(Development Charges Letter)

File No. : CMDA/PP/NHRB/S/1078/2019

Sub: CMDA-Area plans Unit - 'B' Channel (South) – The Planning Permission application received for the proposed construction of Stilt floor + 5 Floors with 8 dwelling units availing Premium FSI of Residential Building at Plot No.7A, D.No.8/16, Srinivasa Avenue Road, Raja Annamalaipuram, Chennai -28. Comprised in Old S.No.4253/2 (Part) as per document and New R.S.No.4253/10 and 75, as per patta Block No.91 of Mylapore Village within the limit of Greater Chennai Corporation- Remittance of DC & Other charges – DC advice Sent - Reg

SITE CUM STILT FLOOR PLAN

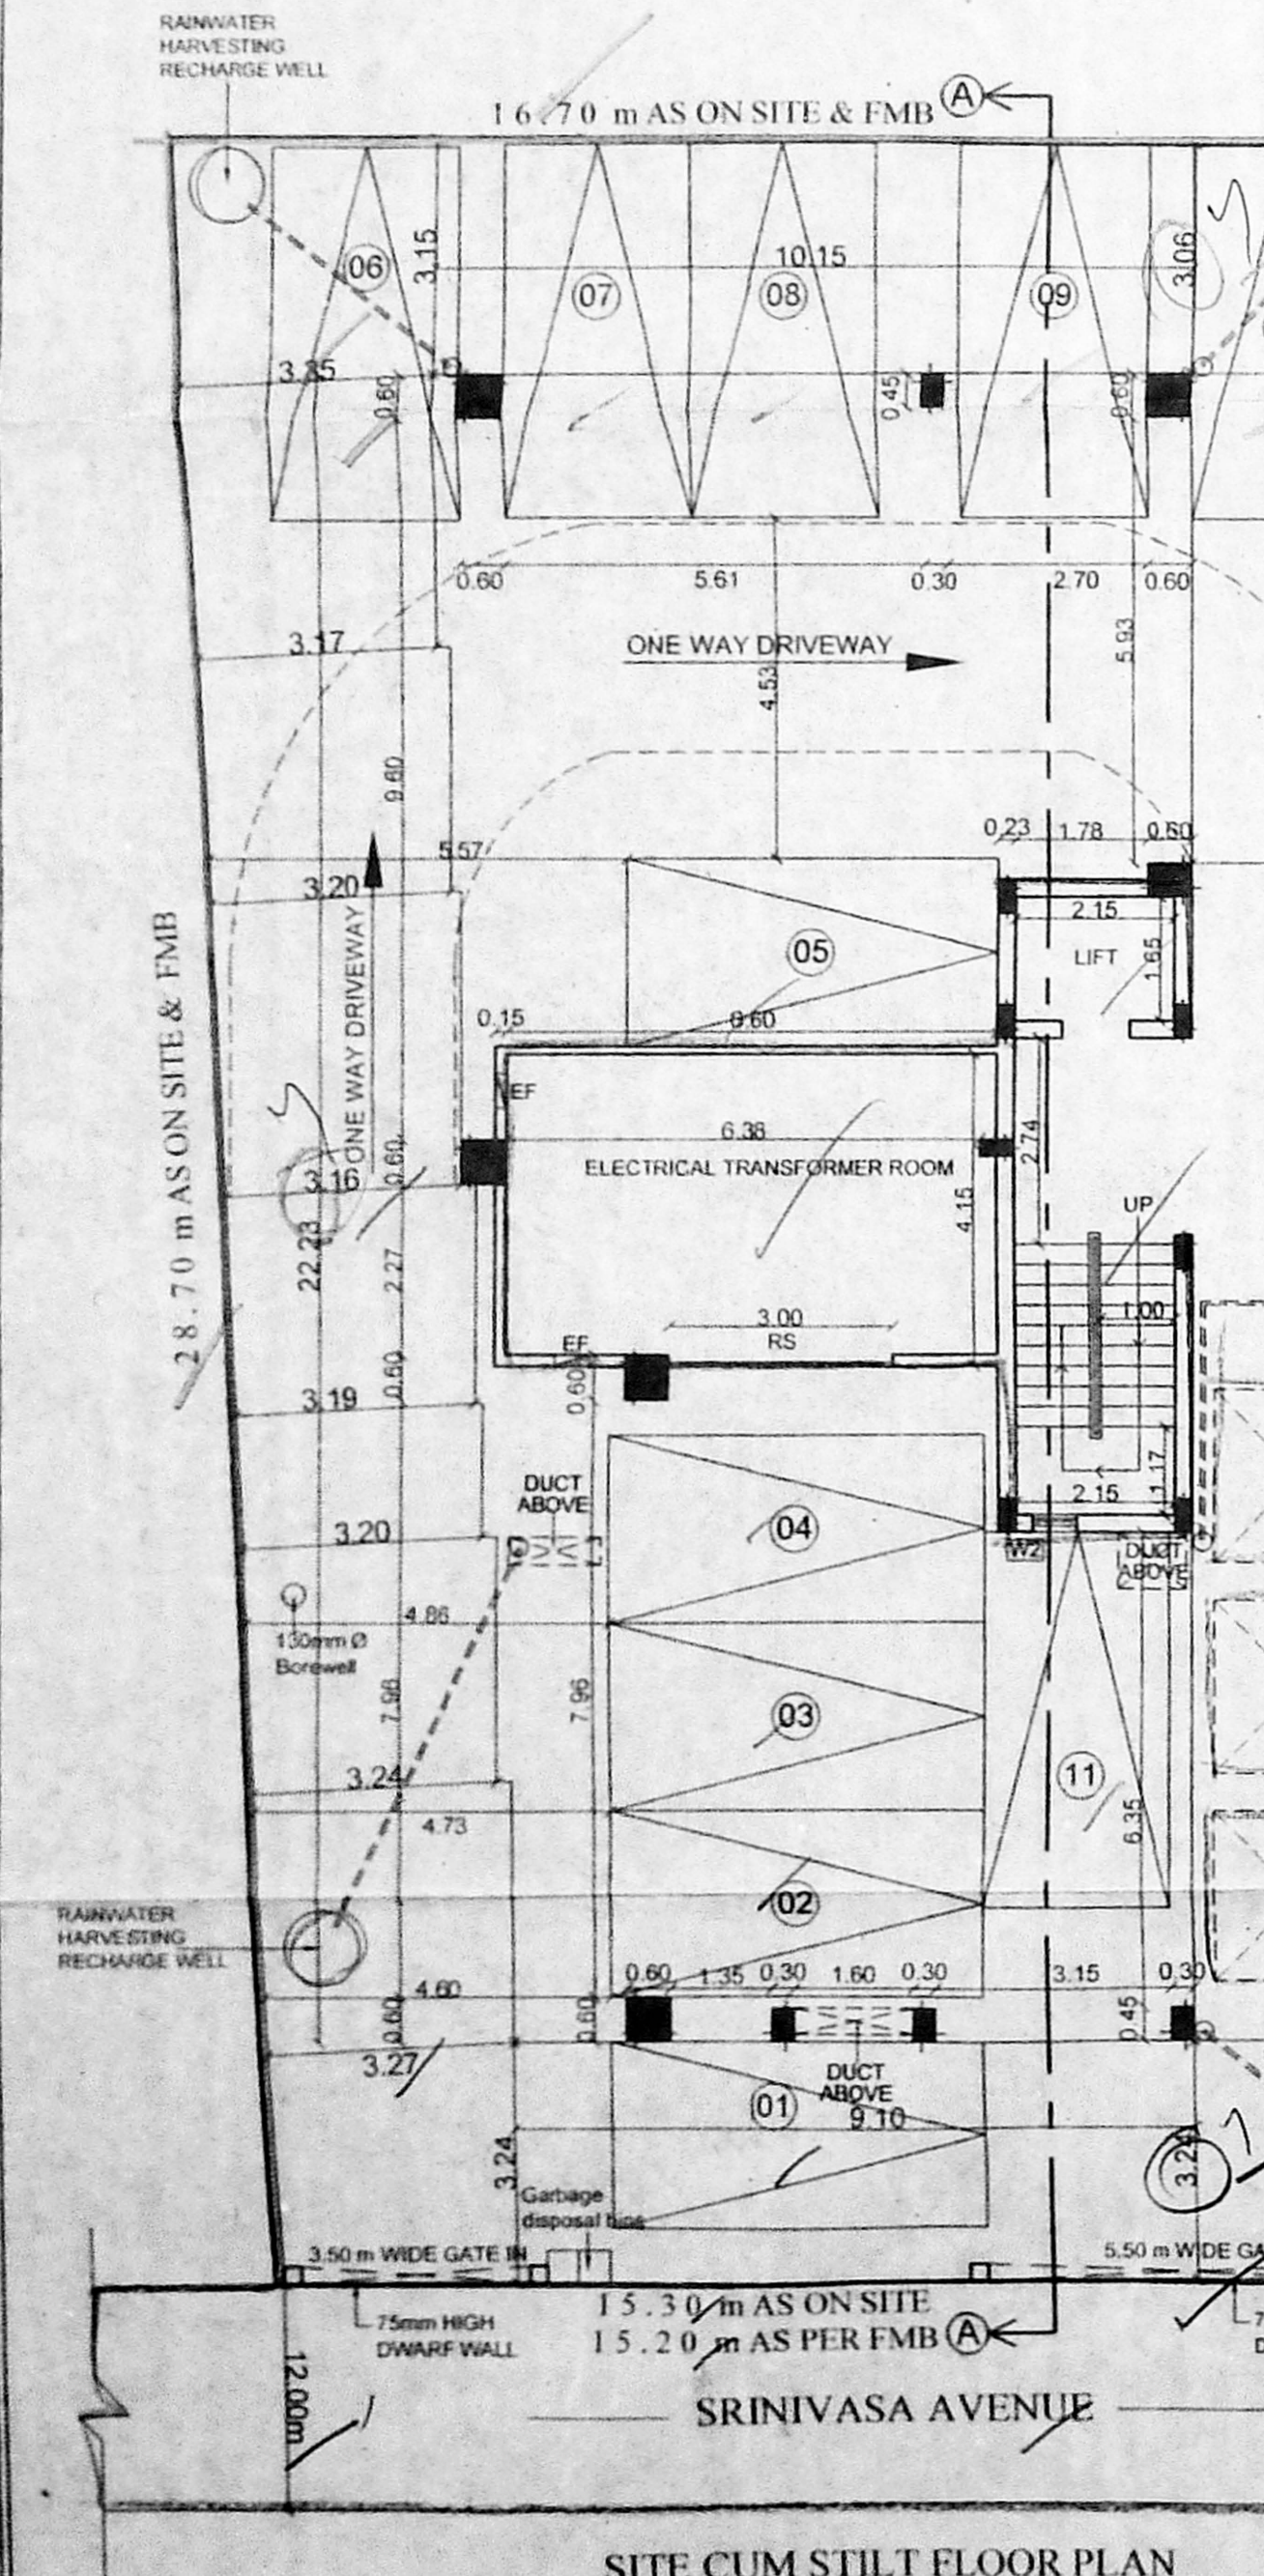
- Correct road width to be mentioned as on site condition in the site plan.
- The Site Boundary as Per FMB and as on site measurement to be shown in the site plan and setback to be shown from the least boundary line, in the site plan.

- Handrail to be shown in balcony of all floor plan.
- Drive way ,turning radius ,aisle width and in the electrical transformer room rolling shutter and 2no of exhaust fan to be provided as per TNCD&BR.in the site plan.

- Demolition approved plan for the existing building in site under reference from the local body to be furnished.
- Car parking lot no.1 and 11 to be rearranged.

SECTION A-A

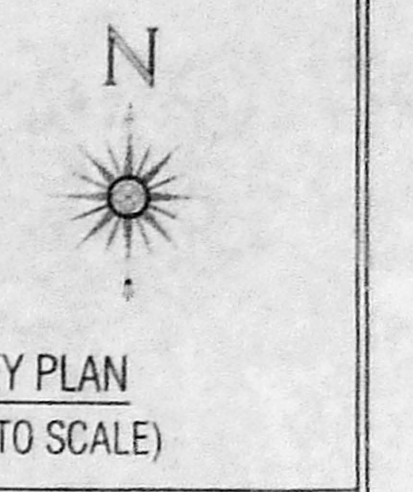
- Area statement and Sections needs correction.
- Head room along with measurement to be shown in the terrace floor plan and breakup measurement to be removed.
